Recommendation Report for Planning Permission for Works or Extension to a Dwelling

REF NO: BR/331/18/HH

LOCATION: 1 Waverley Road
Bognor Regis
PO21 5NB

PROPOSAL: Dormer projection to existing first floor.

sheet 2 of 3

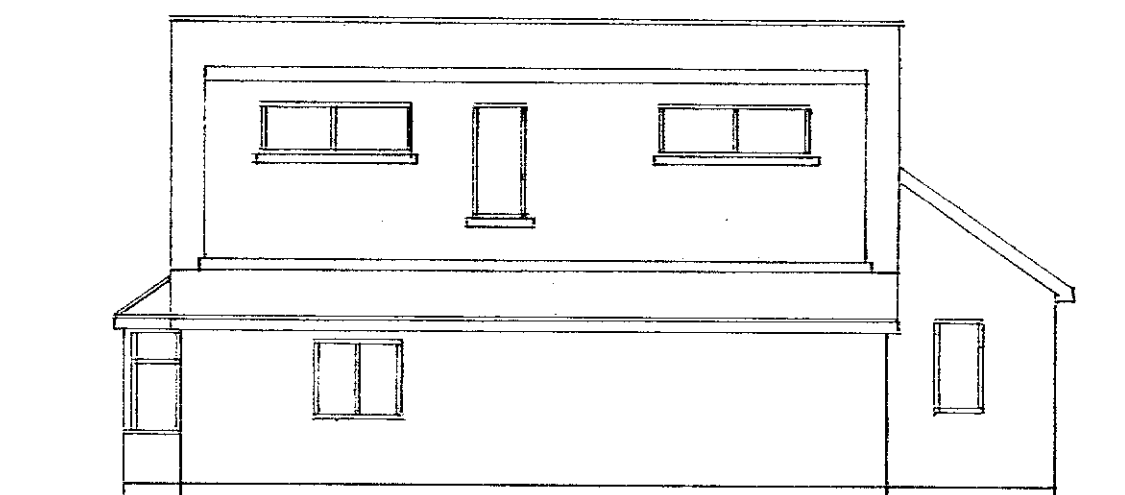
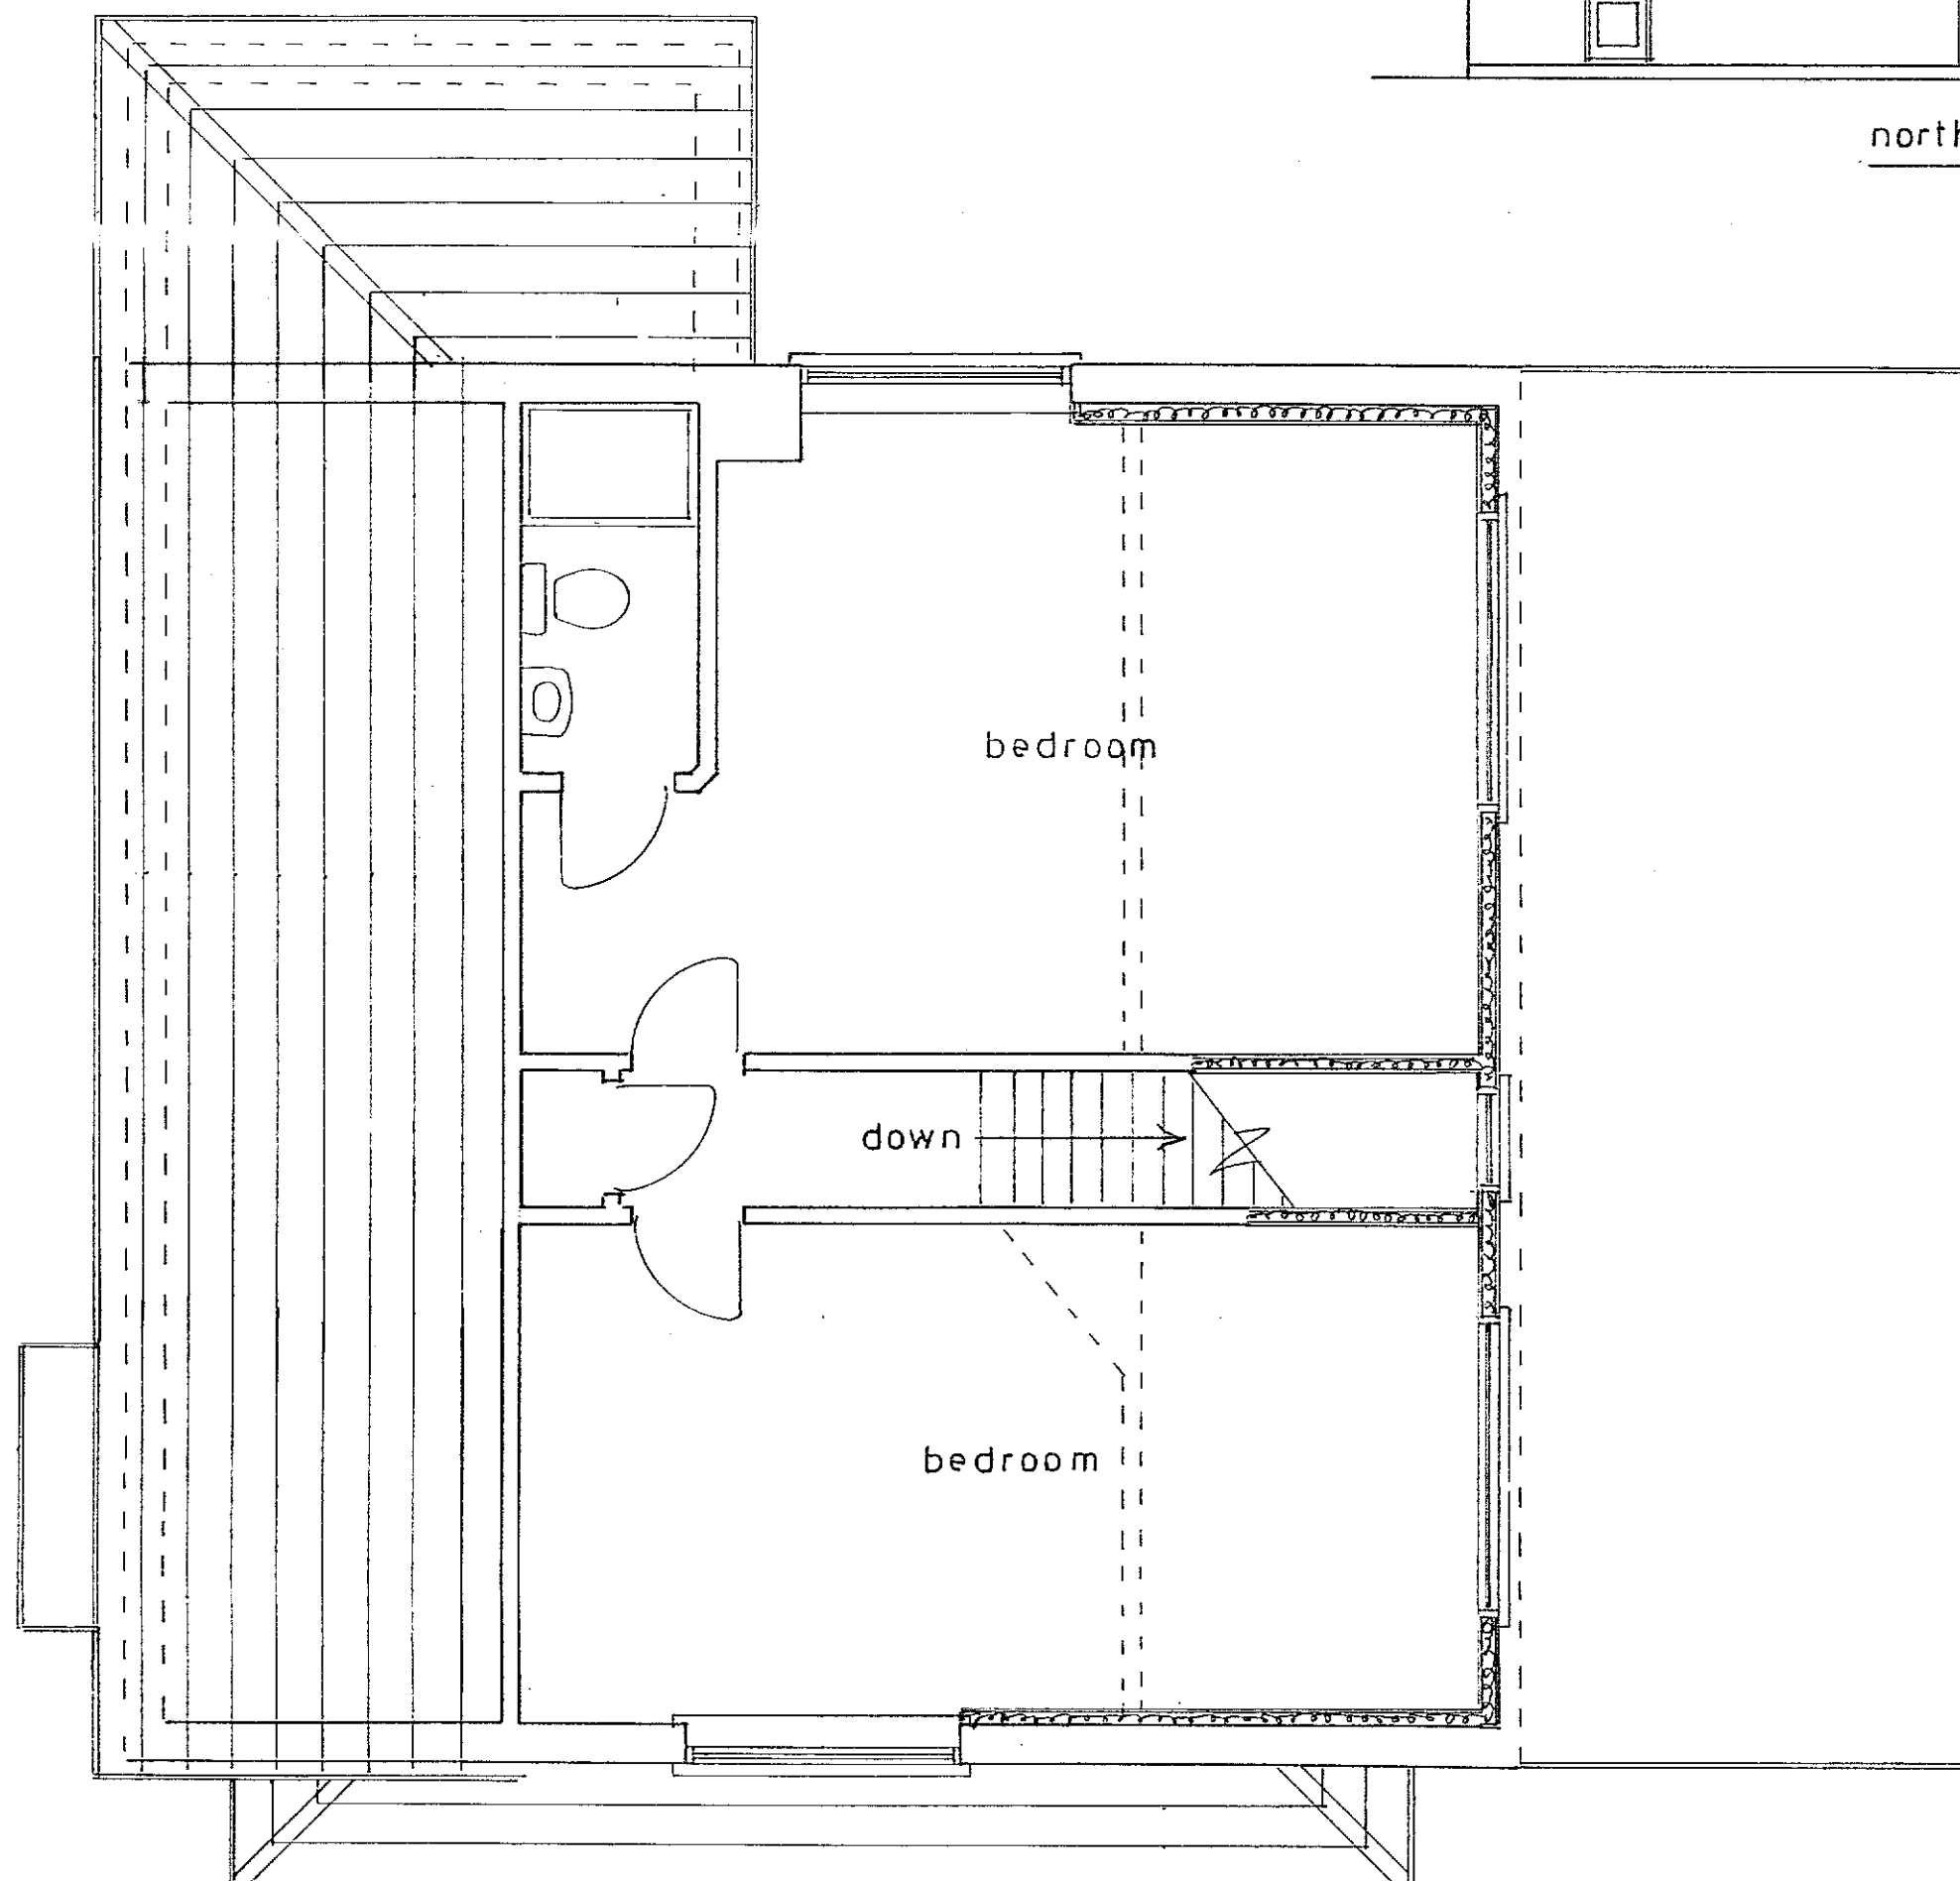
The proposal is highly visible from the street scene and situated to the north east elevation.

The surrounding area consists of a variety of styles and designs and with similar forms of development nearby specifically a dormer at No.2, the proposal is not considered out of keeping with the area. The dormer appears well integrated with the host dwelling with materials to match existing.

The dormer spans 4.35m across the width of the roof. It will have a height of 1.25m and a depth of 1.75m. The dormer is sited round 0.6m below that of the ridge height of the host dwelling and whilst it is relatively large due to its siting and with sufficient distance retained to the boundary it is not considered to appear overbearing or overshadowing.

The proposed dormer would have 3 windows to the north east serving a landing and bedrooms. This directly faces the neighbouring property at No.3 and whilst it may give rise to some overlooking towards this property at single storey there are no first floor windows to the side elevation and as a result it is not considered overlooking would be significant. Due to the siting of the dwelling it is not considered the proposal would give rise to any adverse impacts upon neighbouring amenity to the rear.
